**REQUEST**

Current Zoning: R-3 (single family residential)  
Proposed Zoning: UR-2(CD) (urban residential, conditional)

Approximately 1.82 acres located on the west side of Providence Road, south of Fairview Road, and north of East Barden Road.

The petition proposes to redevelop the single family home site with a infill townhome community with up to 17 units on Providence Road south of Fairview Road.

REZONING PETITION 2021-198

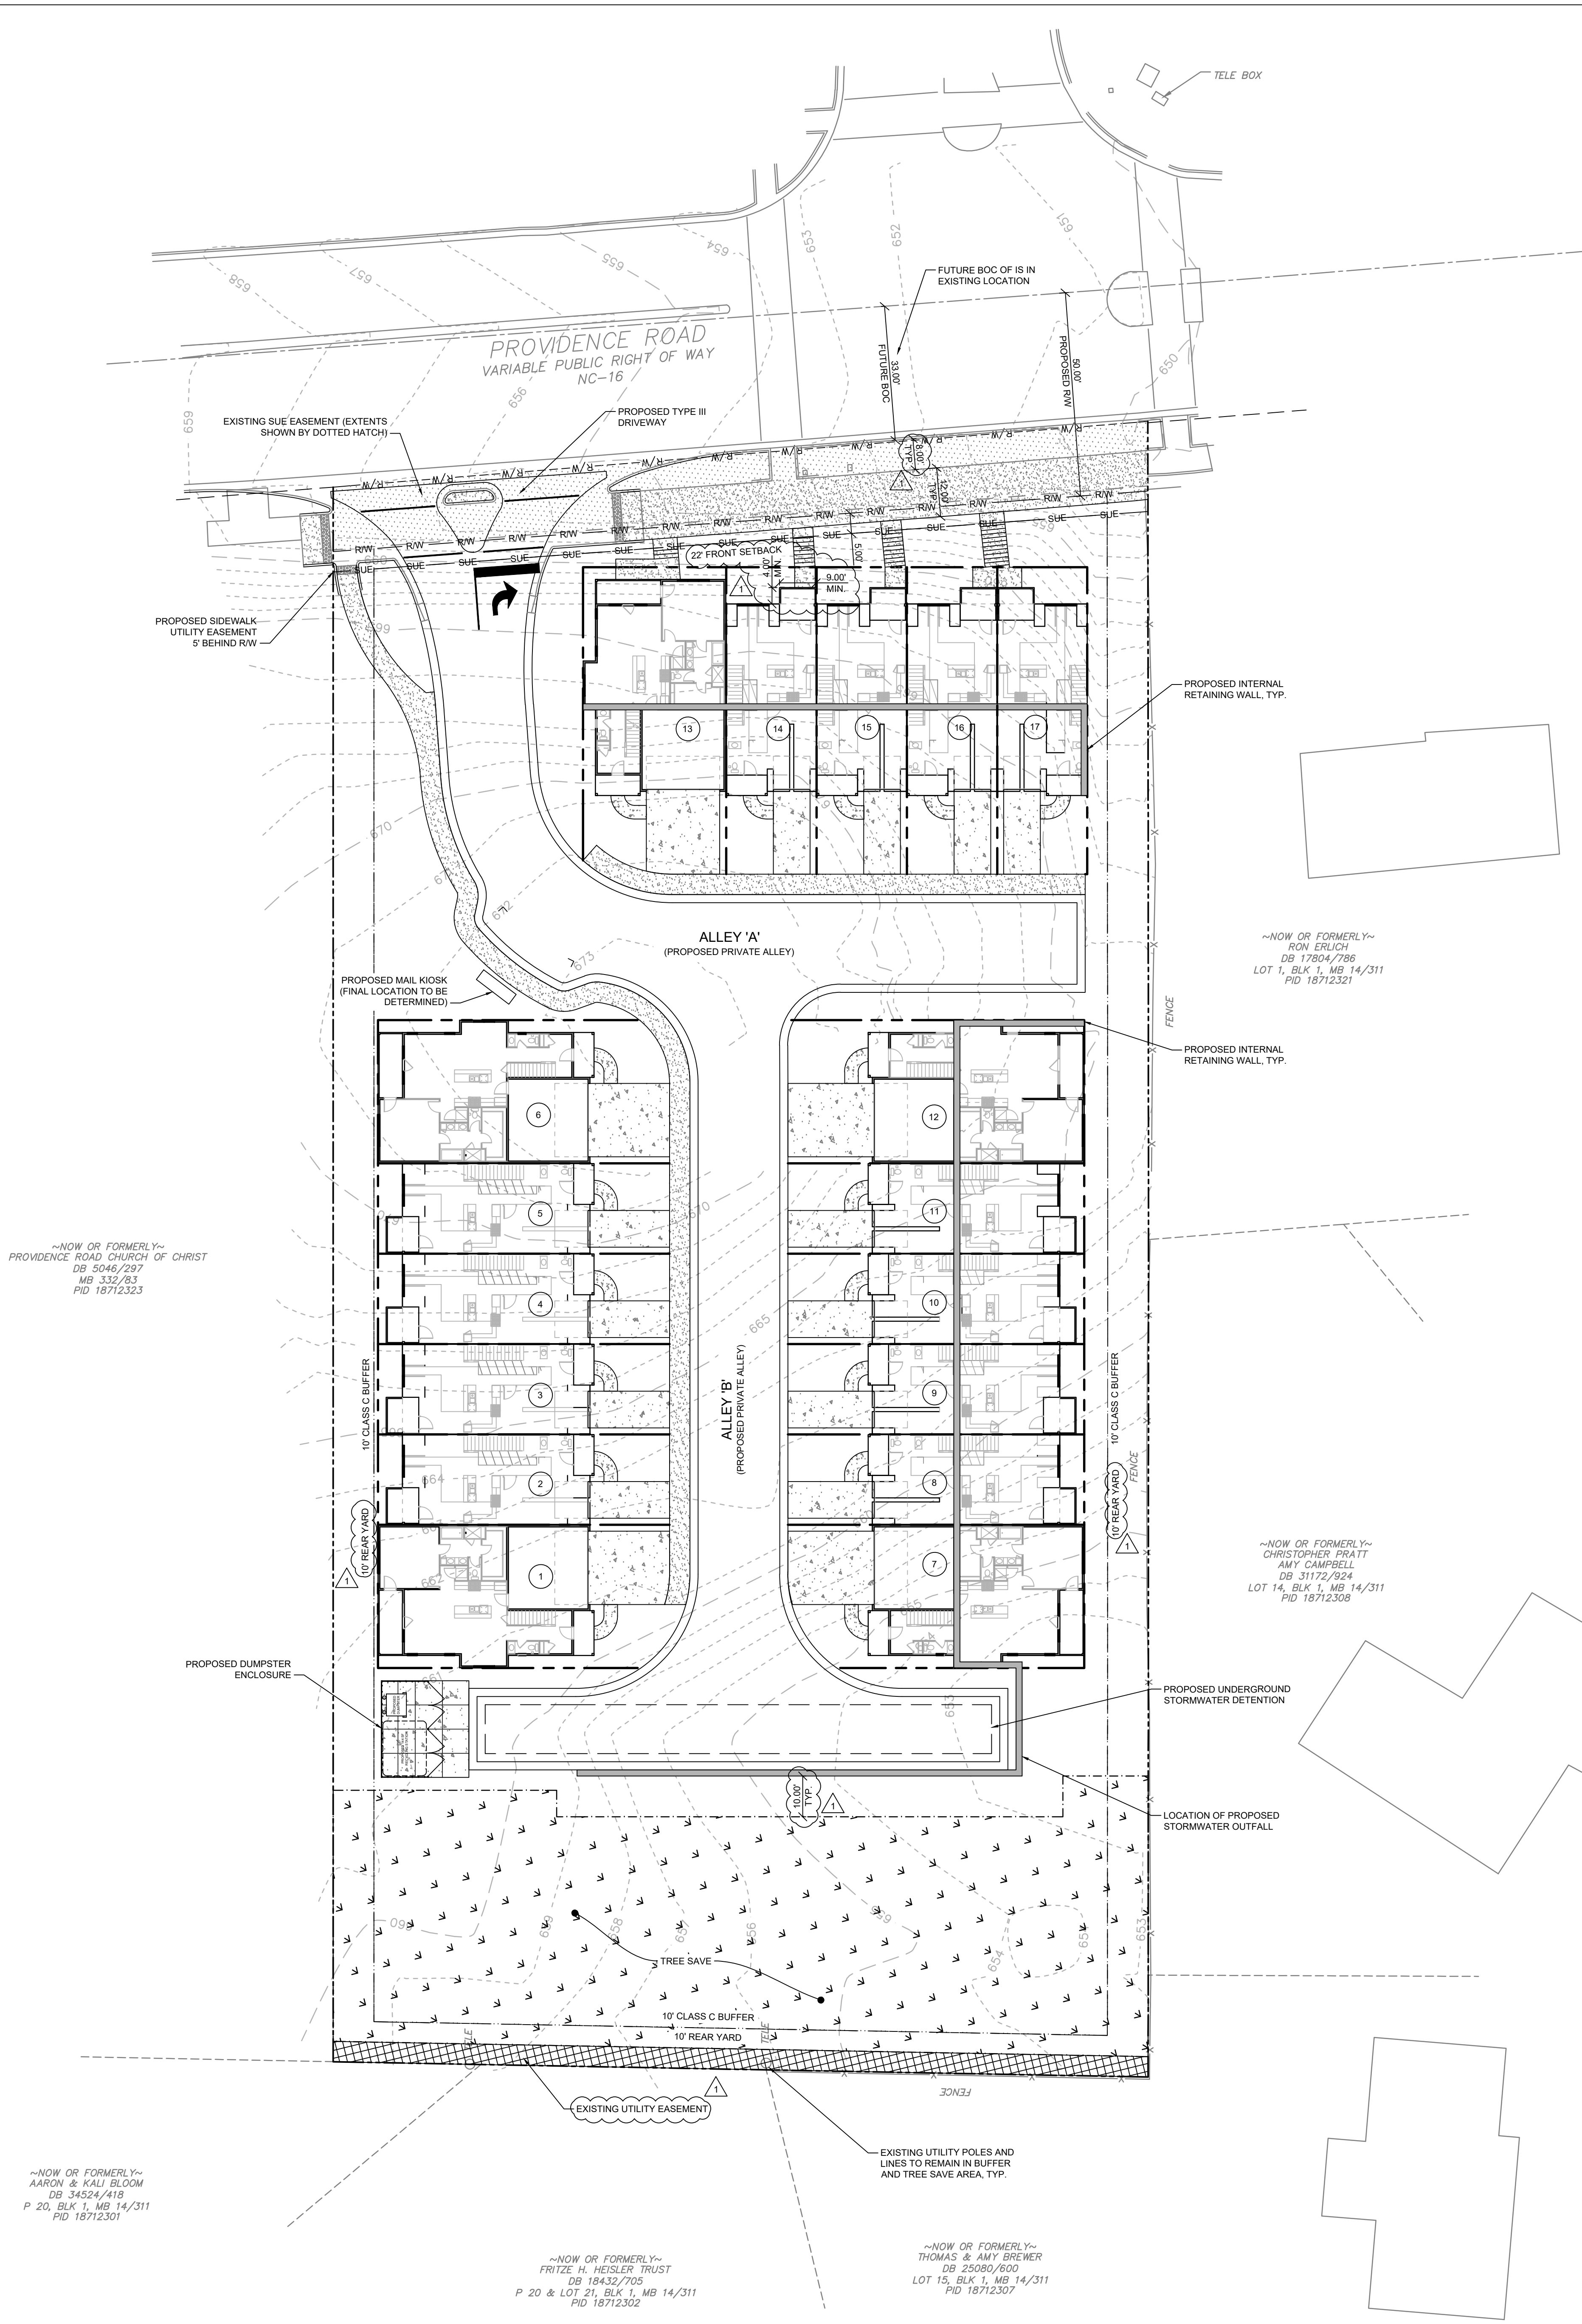
1. Extend the internal sidewalk to the end of Alley B in front of unit 1. Addressed
2. Increase the setback along Providence Rd to 40 ft measured from the future back of curb to be consistent with other rezonings along Providence Rd and to more closely resemble setbacks of other buildings along the street. Rescinded, staff accepts the alternative setback proposed. The petitioner increased the setback from 14 to 22ft.
3. Architectural note 9 is not clear, amend to provide a minimum dimension for "recessed doors" (suggestion is 12" - 24") Addressed, the petitioner provided a minimum recess of 12" and what explain what is meant by lights/high windows in doors. Rescinded, this part of the note was removed.
4. Amend note 5 under Architectural standards related to the facades facing Providence, as it is currently written it conflicts with note 4. Addressed

5. Adjust the site plan to show the future back of curb 33 ft from the centerline instead of 30 ft. Addressed
6. Add conditional notes to the site plan committing to the construction of the 8 ft wide planting strip and 12 ft wide multi-use path. Not addressed

7. Label and dimension the 8 ft planting strip along Providence Rd. Addressed
8. Label and dimension the internal sidewalk. Not addressed
9. Staff suggests reconsidering the proposed 6x9 stoop side requirement or label as stoops as typical and say minimum 6x9. Addressed, the petitioner amended the minimum stoop dimension to be 4x9.
10. Change the side yard labels on the north and south sides of the site to say "10' Rear Yard." Addressed

11. Adjust existing utility poles and lines or adjust the Tree Save area because utility poles and lines cannot be located within Tree Save areas. Adjusted the tree save area to show a utility easement at the rear where existing poles/lines are located.
12. Consider the addition of the requested Stormwater note related to concerns of stormwater runoff from this site to adjoining parcels. Addressed.
